DRB Application No.: 03-00202 (P&F)  
Project Name: SYMPHONY SUBDIVISION  
Agent: RALPH CORRIZ

**Project Number:** 1002369  
**Application Number:** 03DRB-00202

**CITY OF ALBUQUERQUE**  
**Planning Department**  
**Development Review Board Comments**  
**February 19, 2003**

**RE: Symphony Subdivision, MRGCD MAP 35, Lands of Corriz**

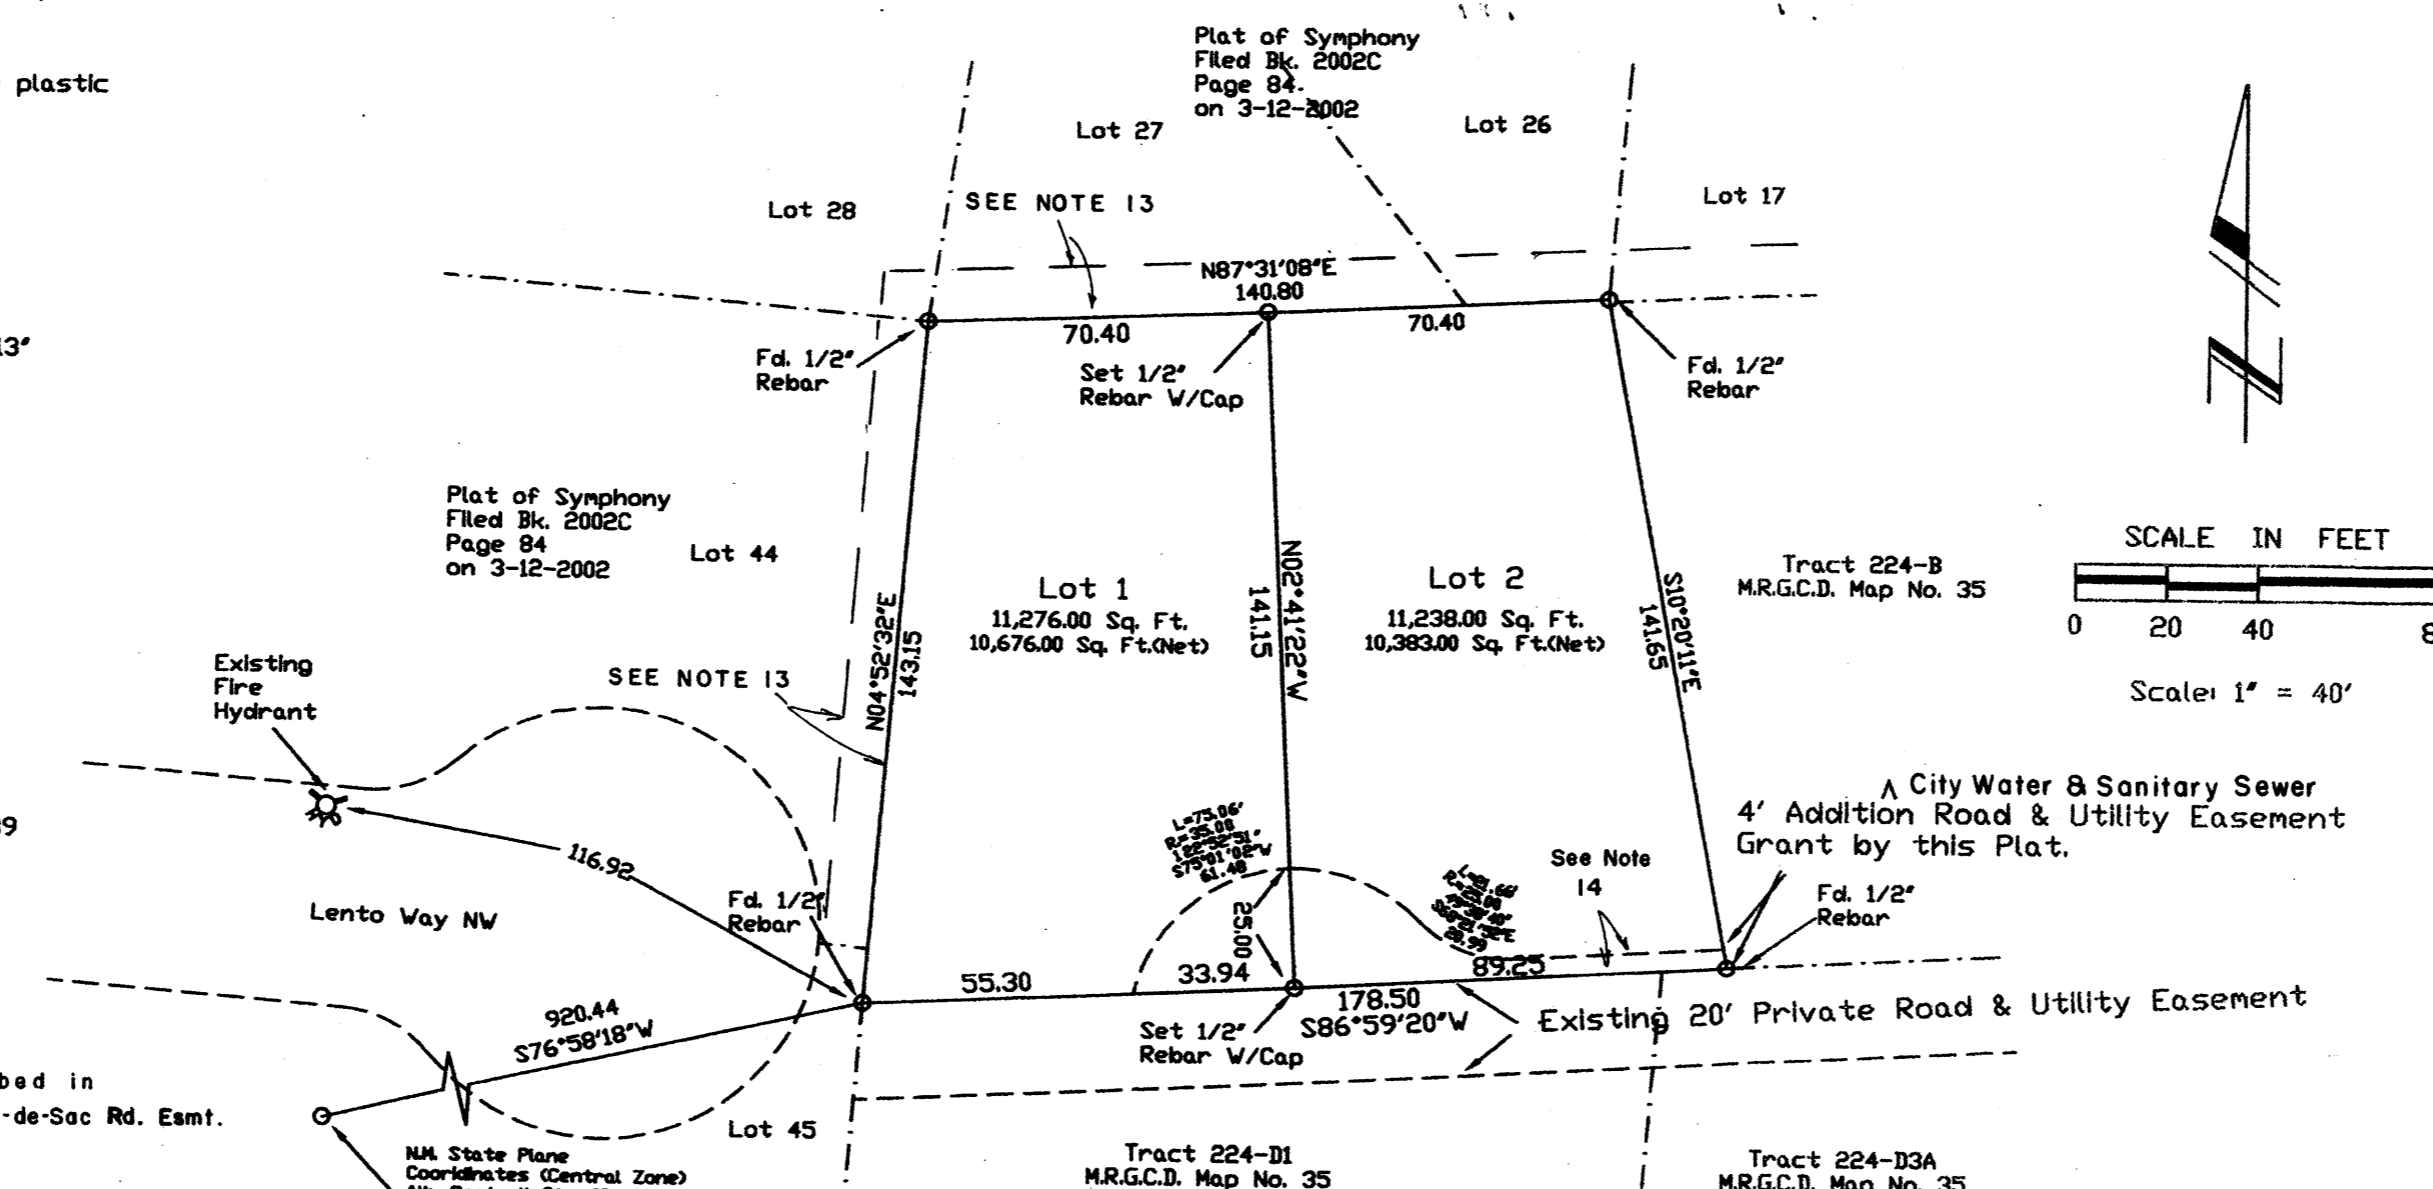
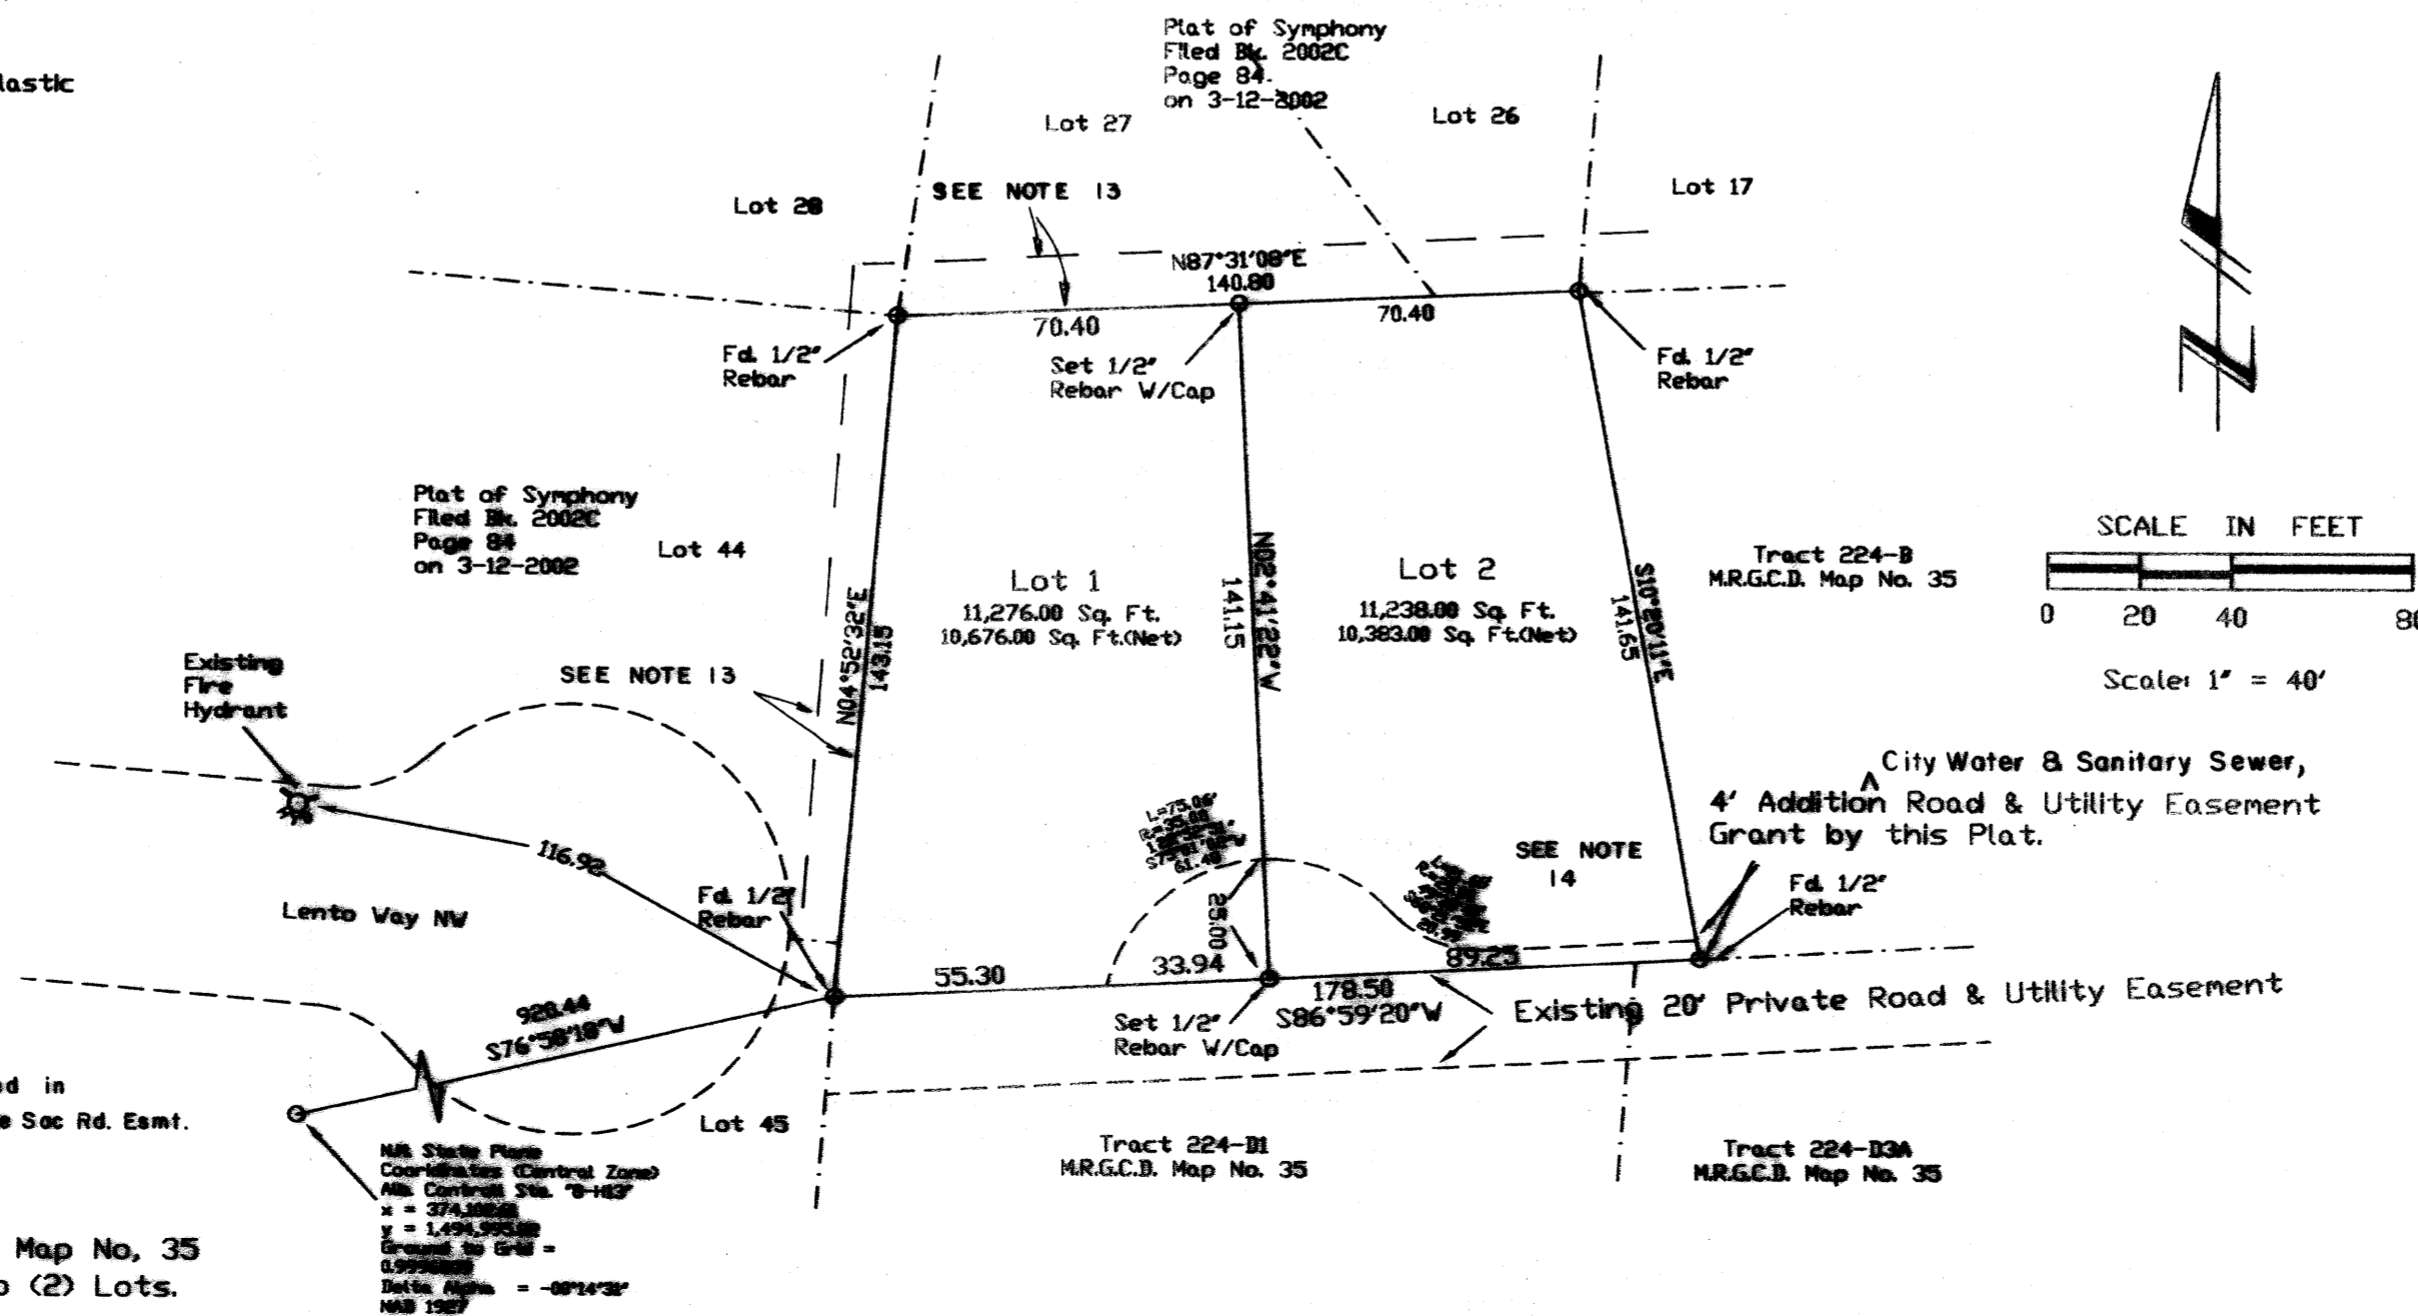
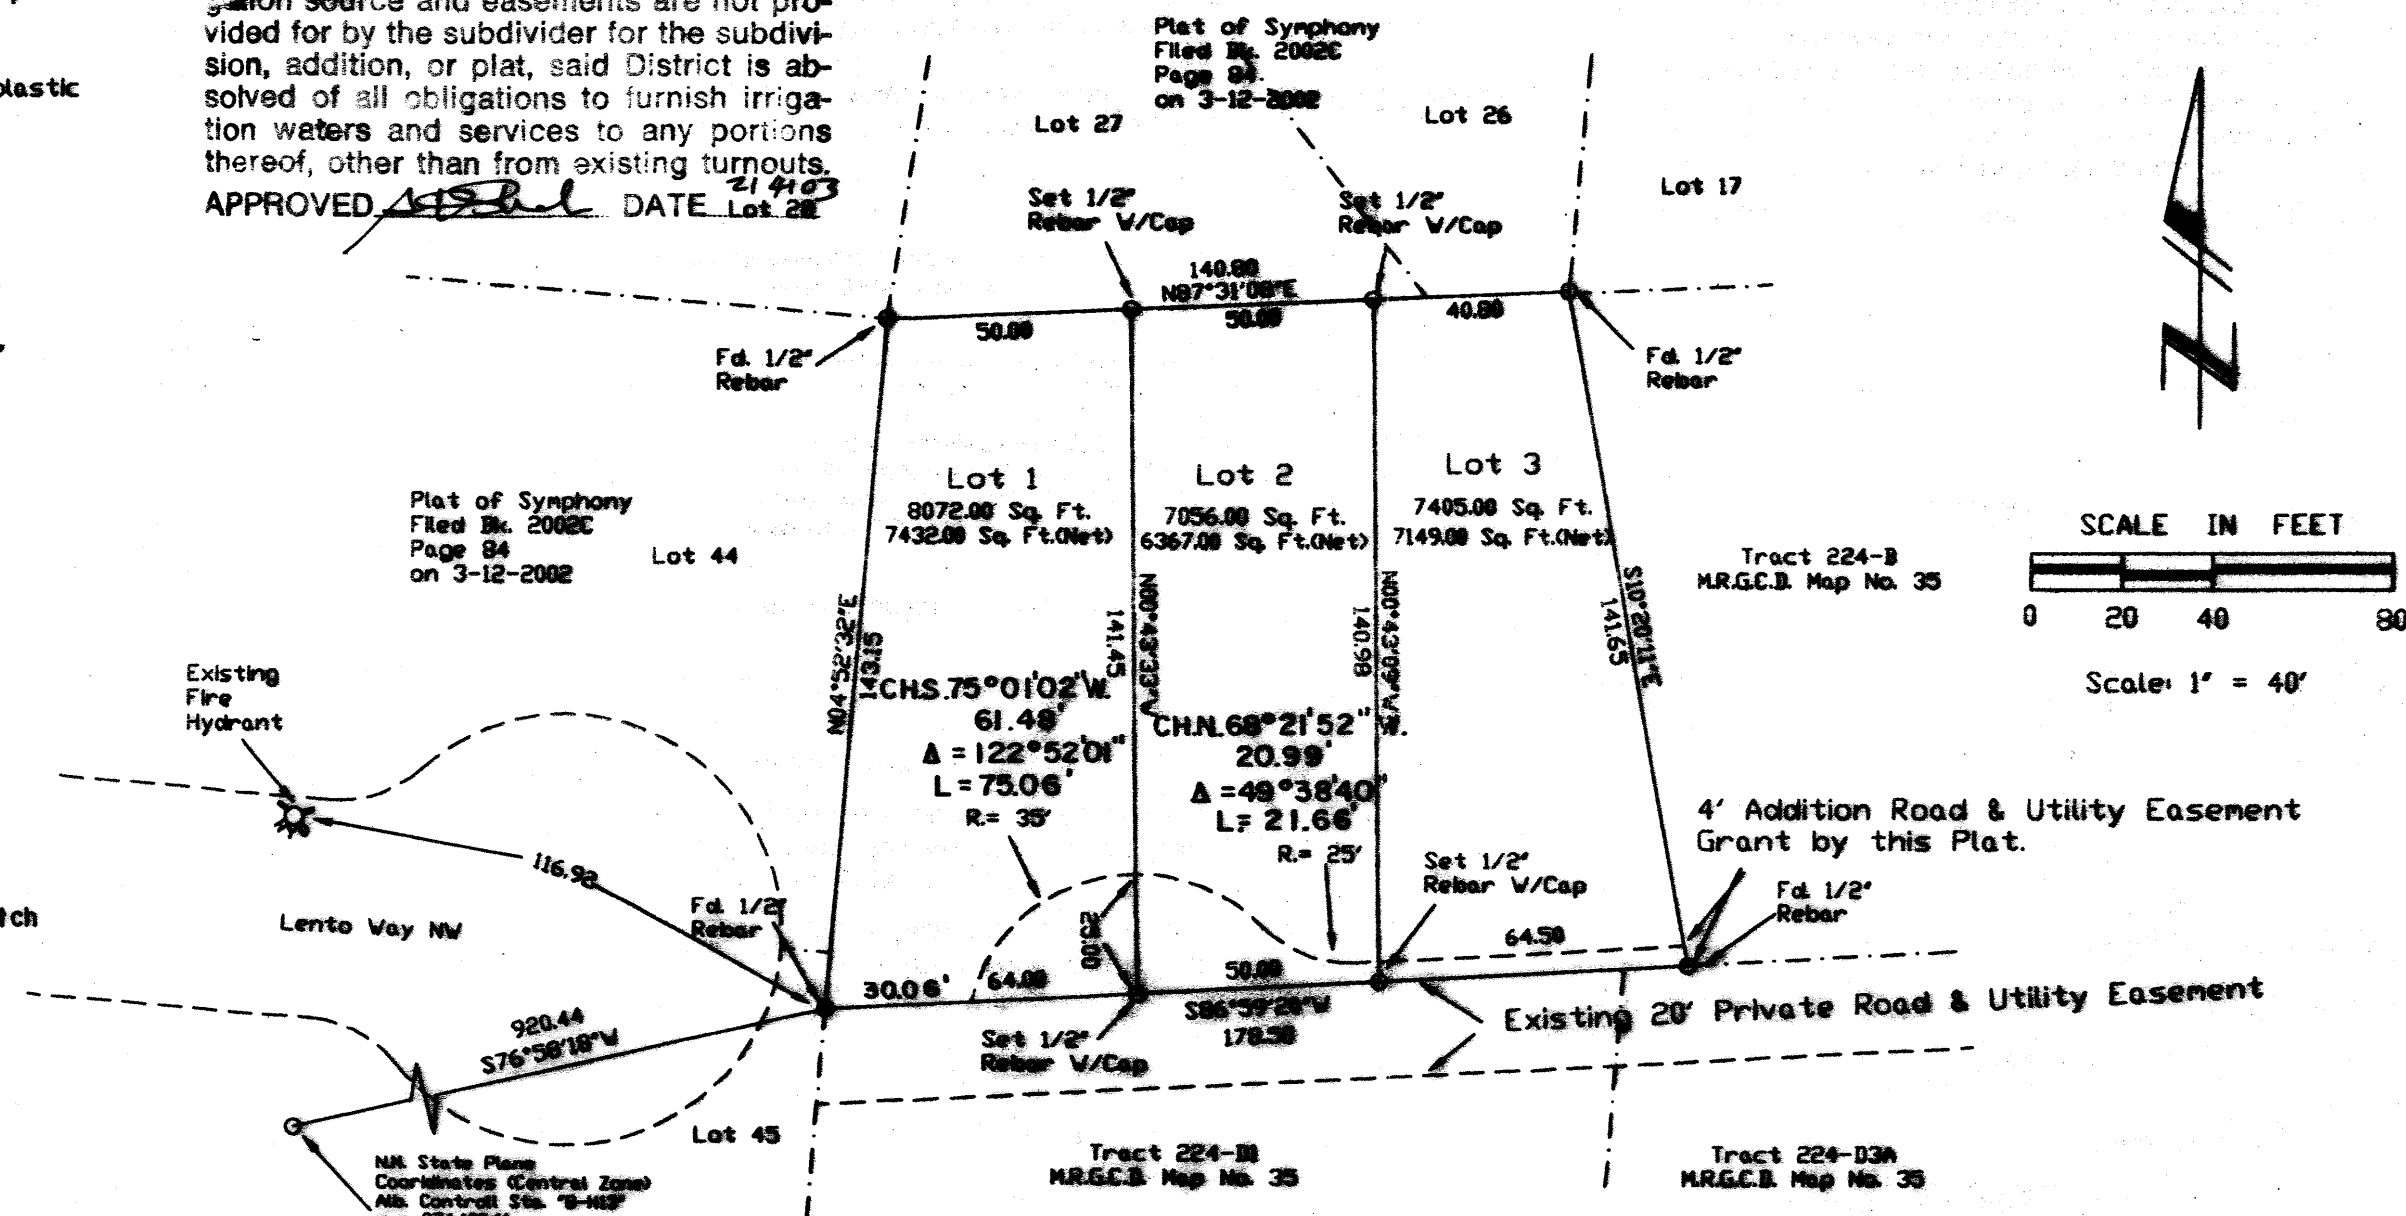
No.	Comment
<input type="checkbox"/>	Make sure that the maintenance parties are the lot(s) included on the plat. The beneficiaries extend to more than the lots that are part of the plat.
